Recommendation Report for Planning Permission for Works or Extension to a Dwelling

REF NO: BR/170/18/HH

LOCATION: 56 Corbishley Road  
Bognor Regis  
PO22 9HS

PROPOSAL: Single storey rear conservatory extension.

| Drawing No. 167/18 -- Scale: 1:100                 |  |

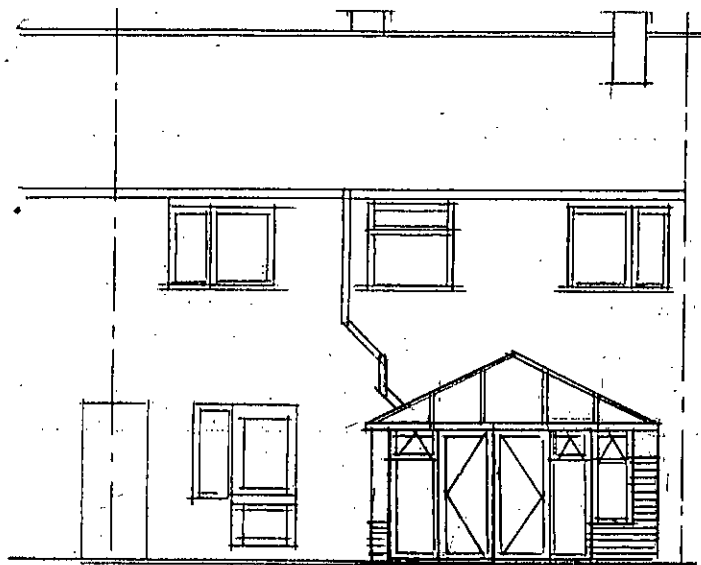
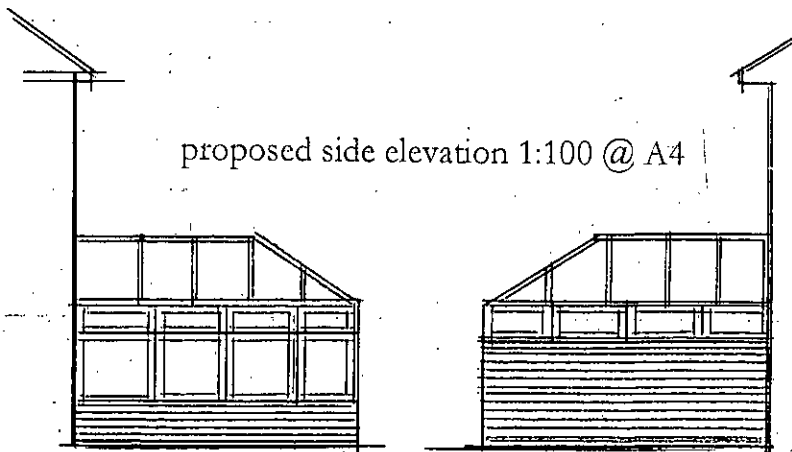
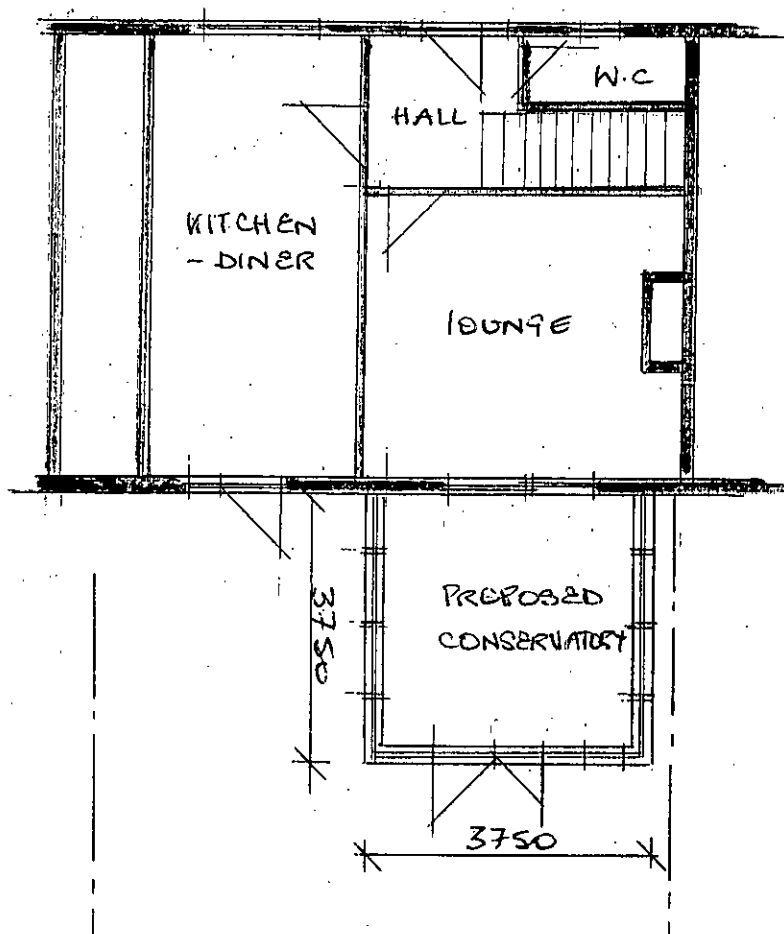
The application seeks planning permission for the erection of a conservatory. The proposed rear extension will measure approximately 3.7m in depth, 3.7m in width and with a height of 1.6m to the eaves and 2.7m to the pitch.

The proposed addition is situated at the rear of the property and will not be visible in the street scene. The proposed extension due to its siting and size is considered well integrated and subservient to the main dwelling. The materials used will match that of the existing dwelling and it is considered that development will not have any unacceptable adverse impacts upon the character of the area and will accord with DDM1 and DDM4 of the Arun Local Plan. Bognor Town Council has a 'made' Neighbourhood Plan however none of the policies are considered relevant to this application.

It is considered the proposal will appear well integrated with the host dwelling. The proposed extension will be situated away from the boundary line and will be approximately 24 from the Southern and rear garden boundary. By virtue of the proposals siting, design and scale it is considered that the development will not result in any harmful overbearing, overshadowing and overlooking impacts upon the neighbouring residential amenity and therefore in accordance with policies DDM1 and DDM4 of the Arun Local Plan.
